# AQUIND: Comments from WCC Landscape (Natural Environment & Recreation Team) January 2020

**Application document reference 2.7
 Indicative Converter Station Area Layout Plans
 Option B(i)
 Sheet 2 of 3**

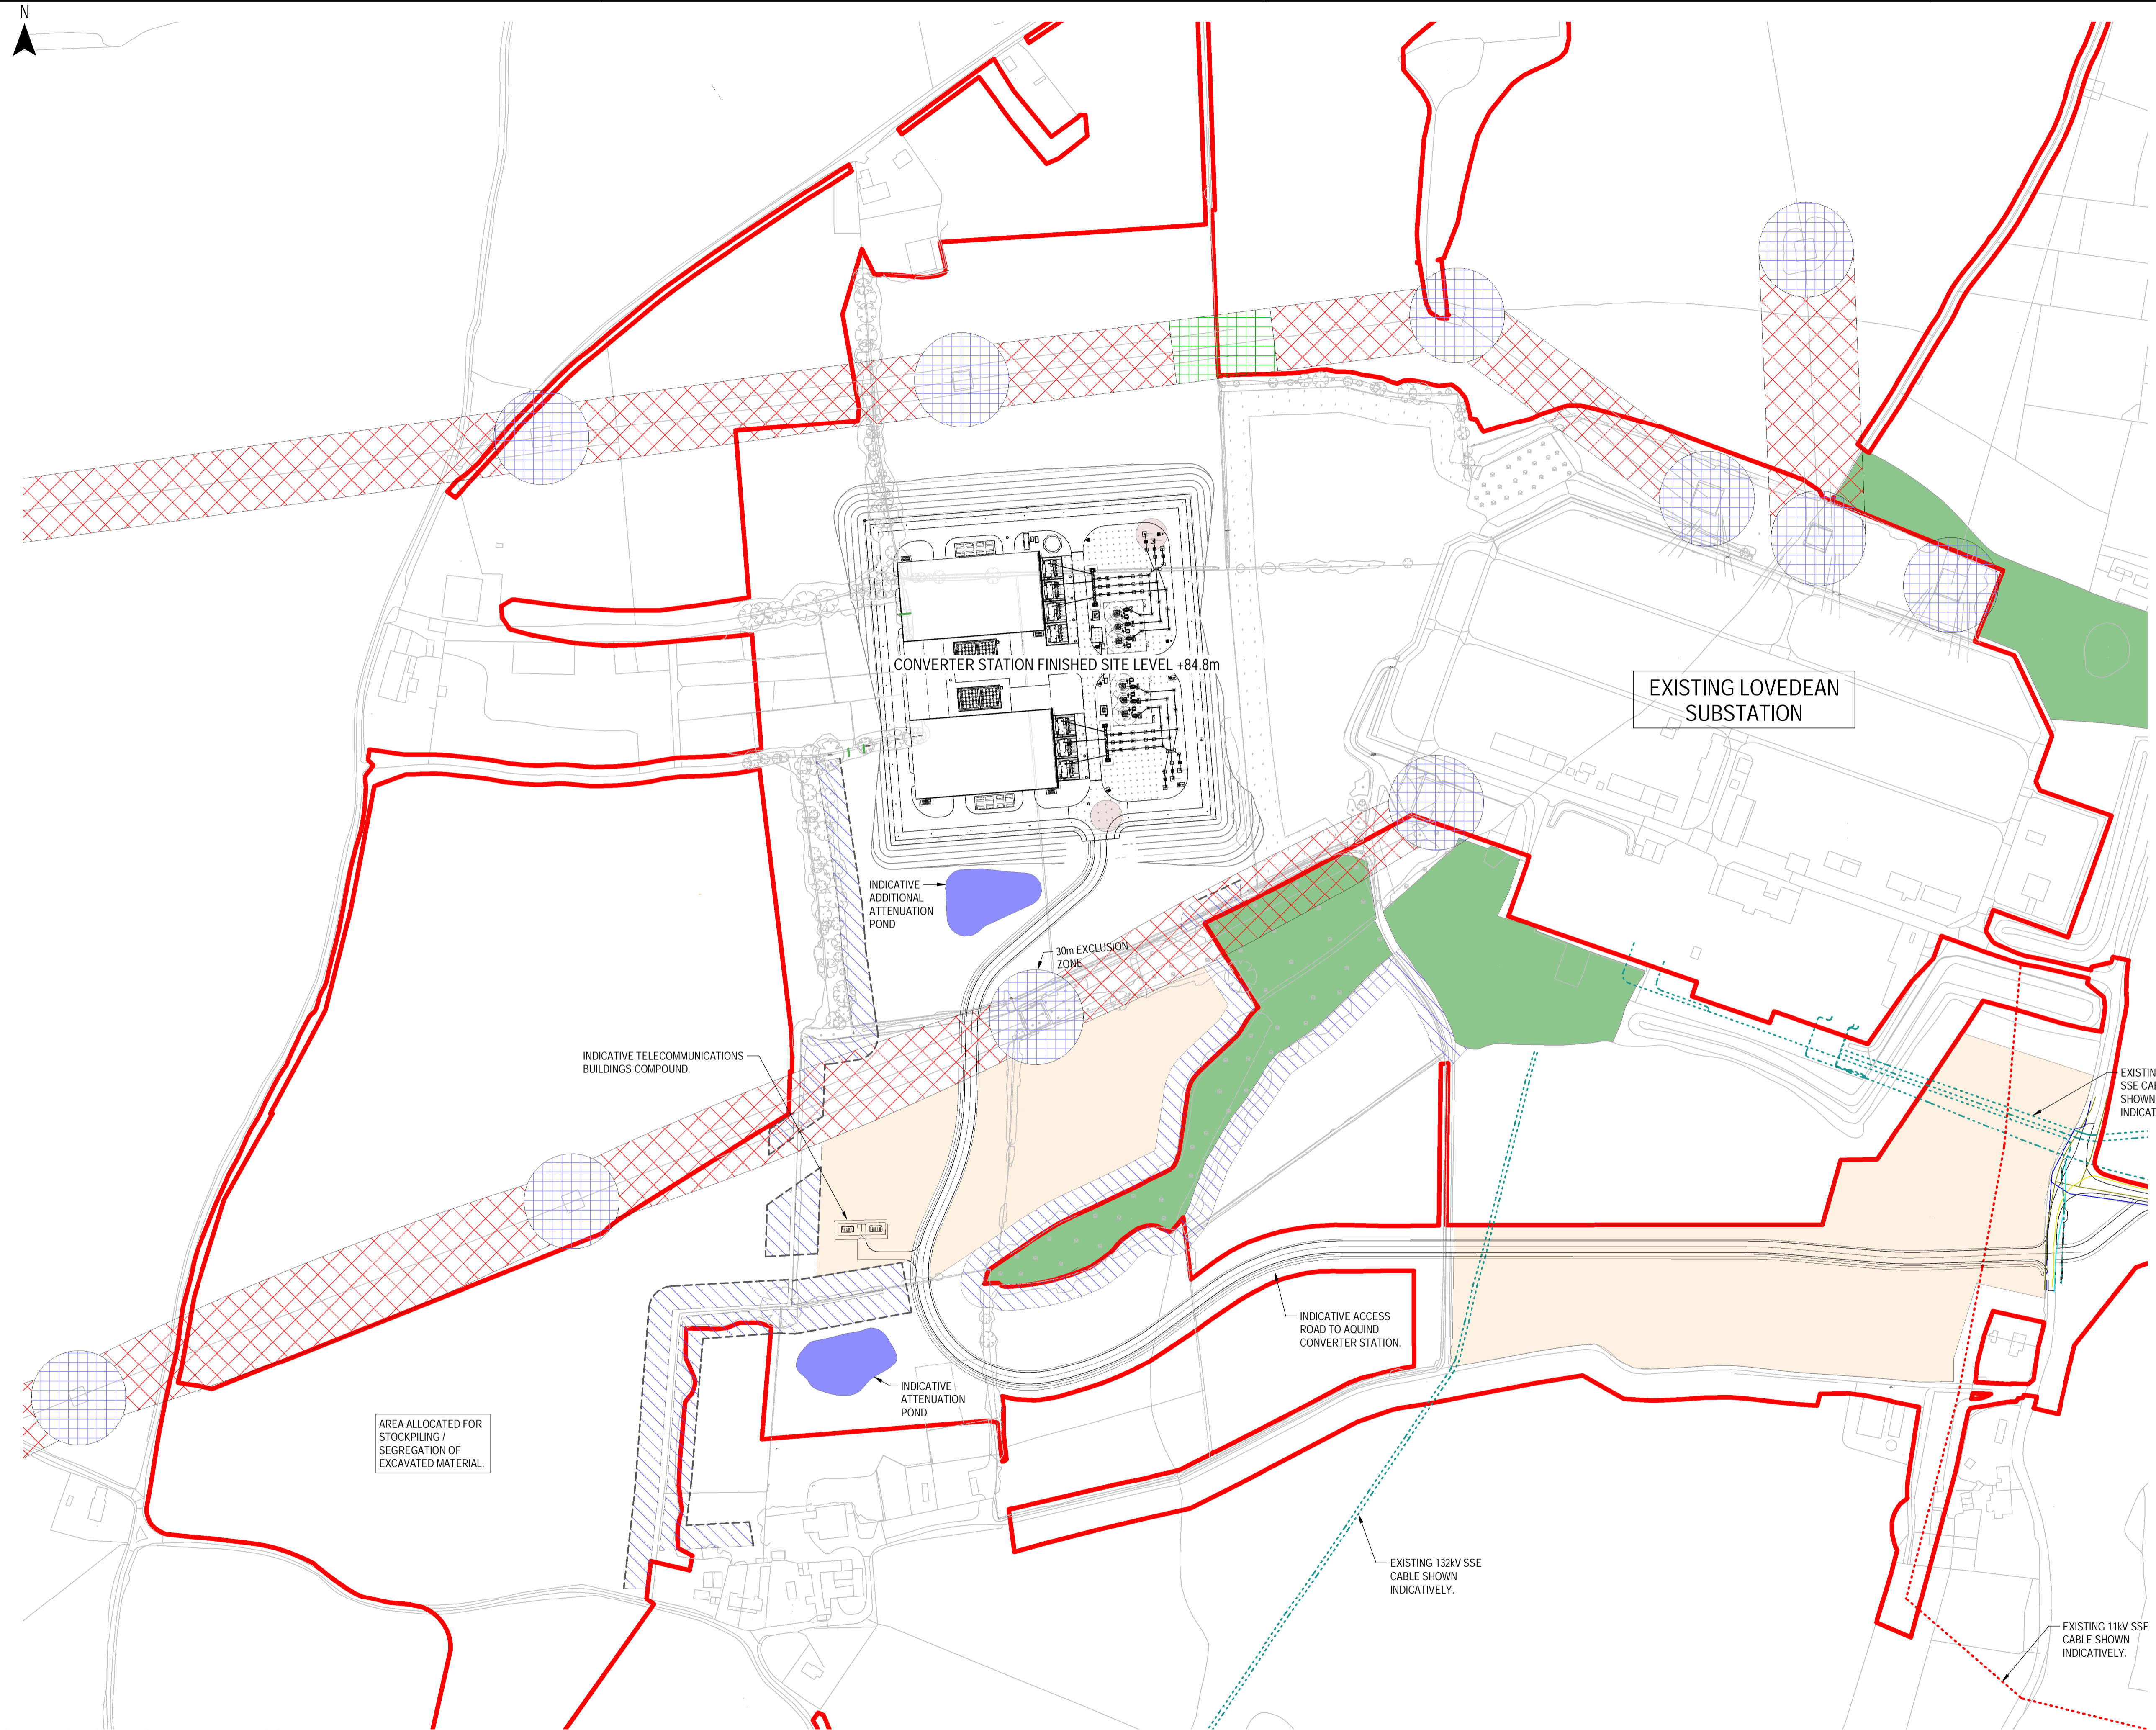
2.7 '**Indicative Converter Station Area Layout Plans**' illustrates, for the first time, a second option for the footprint of the Converter Station (Option B (ii) ) which *avoids* the removal of the 'important' hedgerows (HR10/ HR14/HR09 which are listed in Schedule 12 of the DCO Part 7 Article 41), about 25 mature Oak trees and a badger set.

Schedule 12 –'removal of important hedgerows' NB *includes* the hedges which layout Option B(ii) proposes to avoid.

**Application document reference 2.7
Indicative Converter Station Area Layout Plans
Option B(ii)
Sheet 3 of 3**

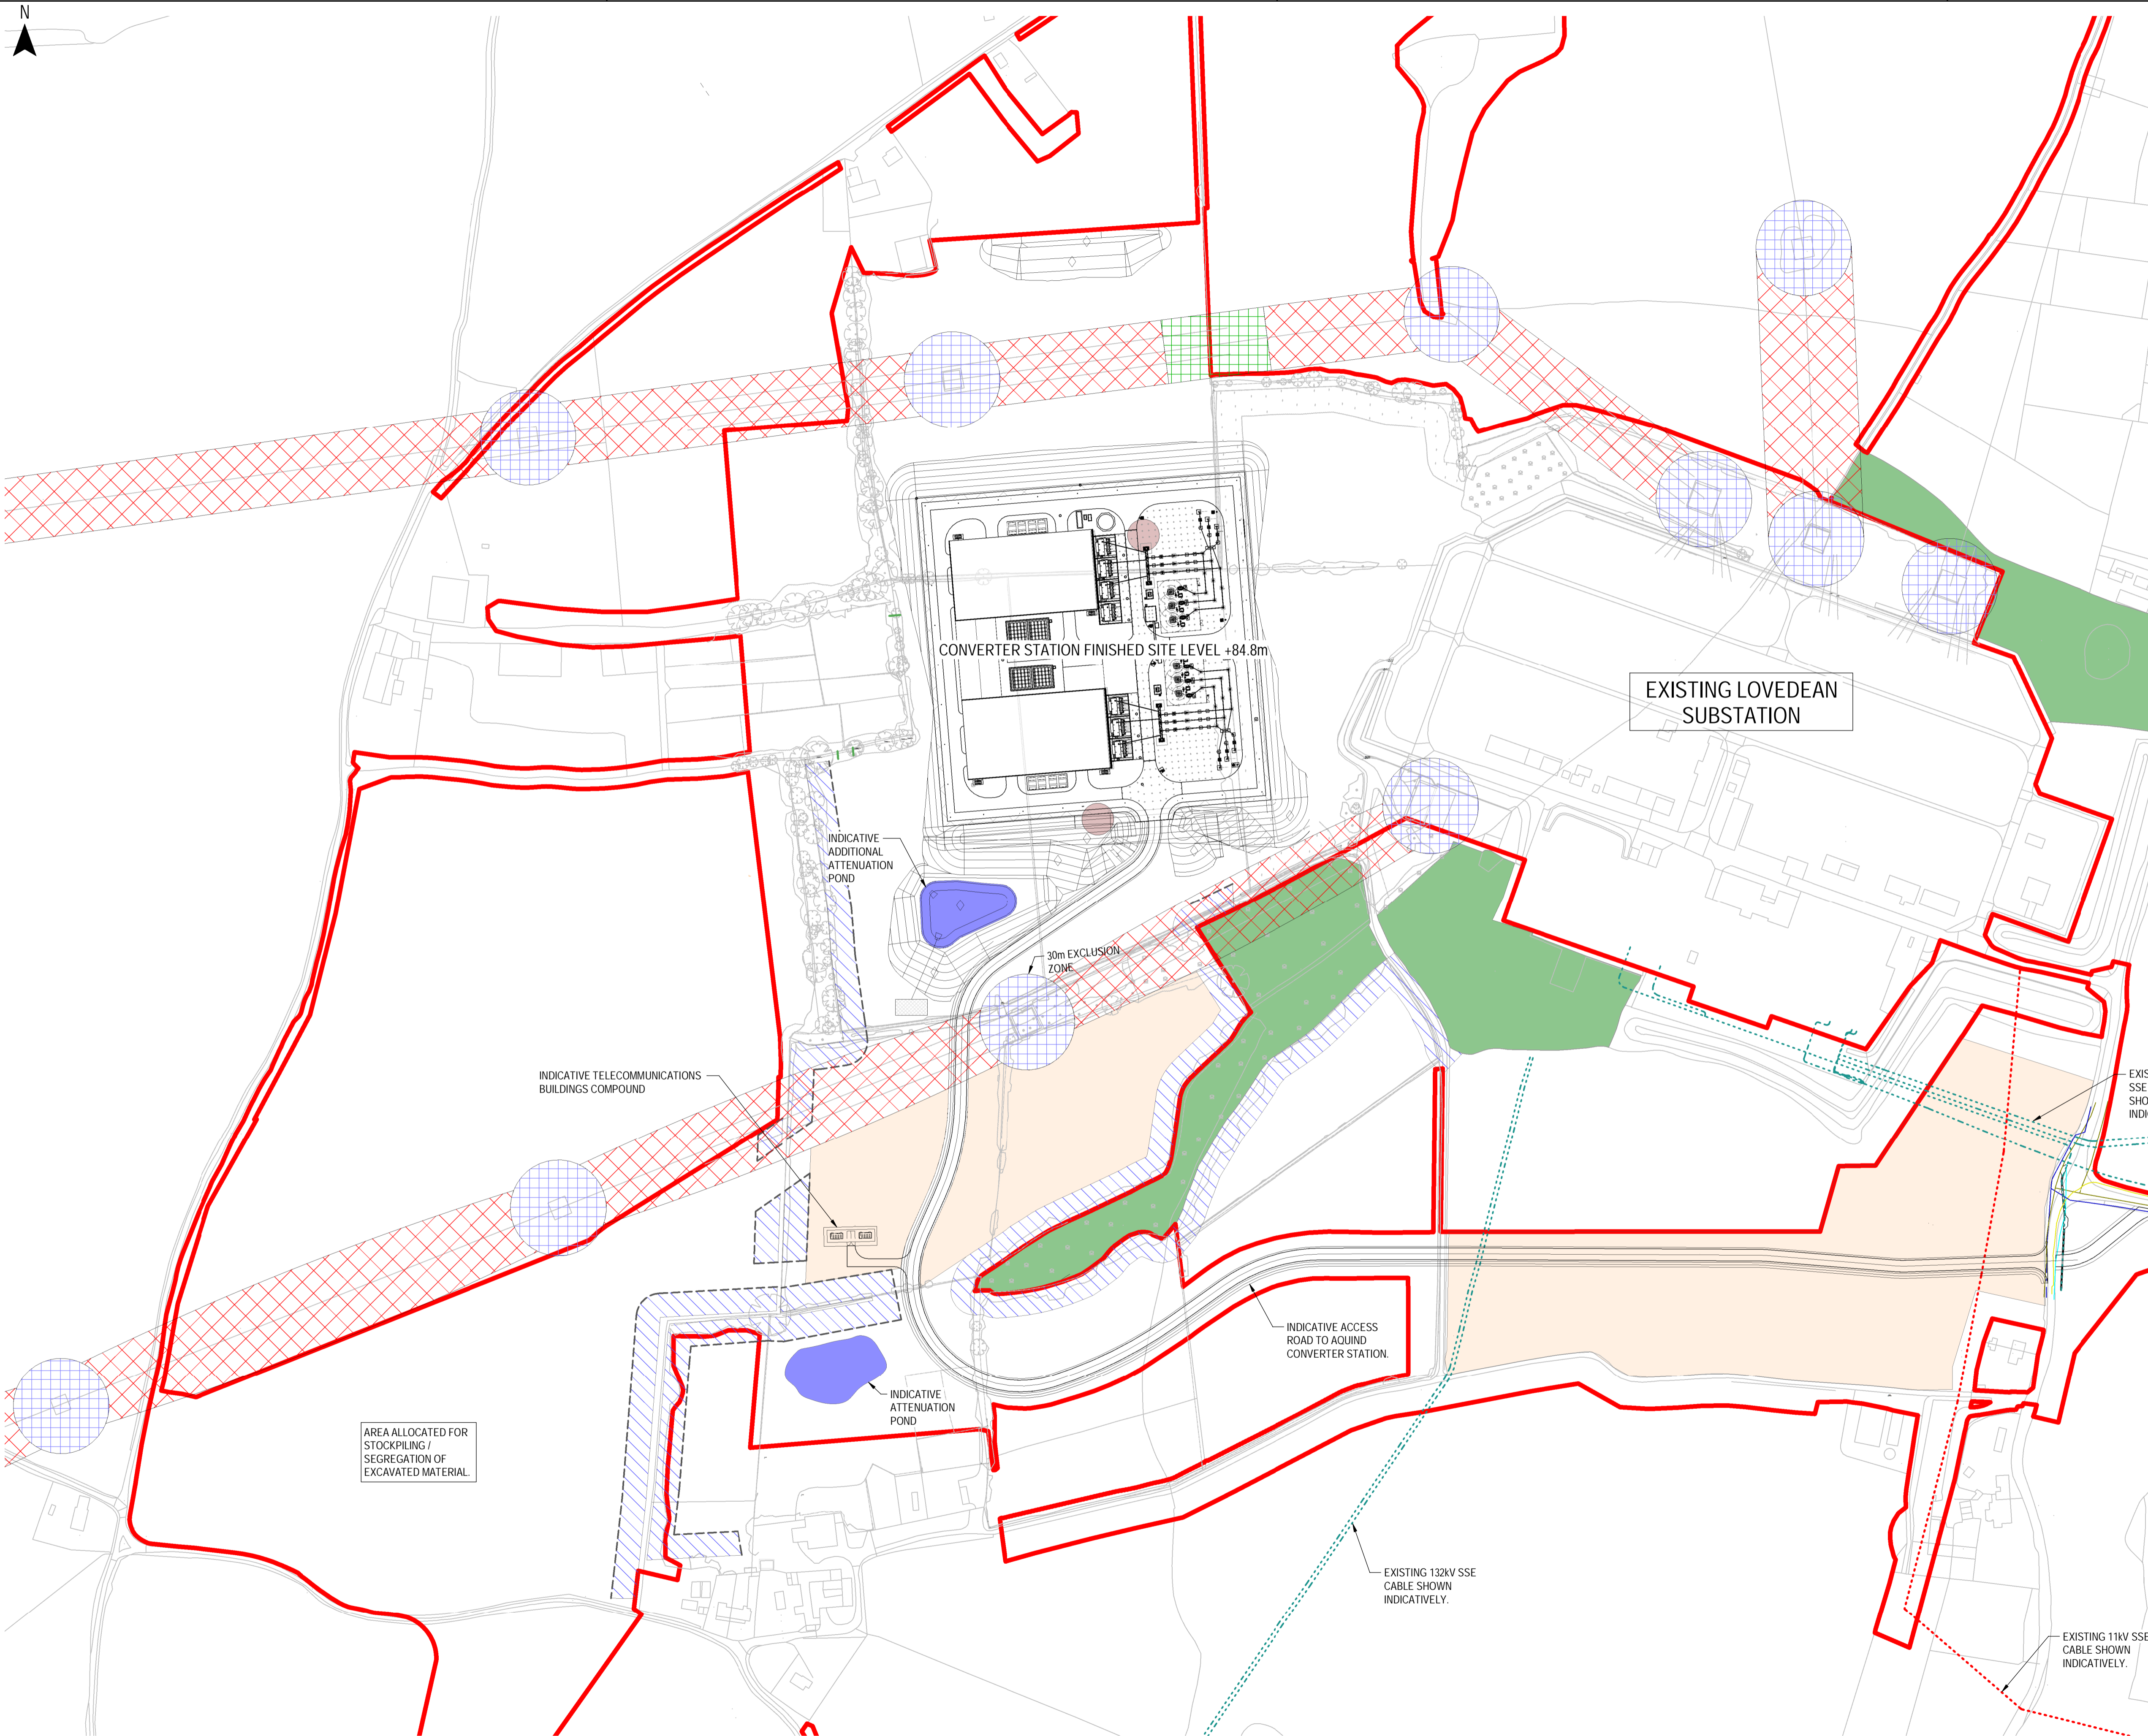
This option, rather than Option B (i), should be the option which the Council pursues because, as well as their connective ecological value (ref WCC Ecology comments?), these hedgerows and trees would also assist in screening the converter station, particularly from viewpoints to the west.
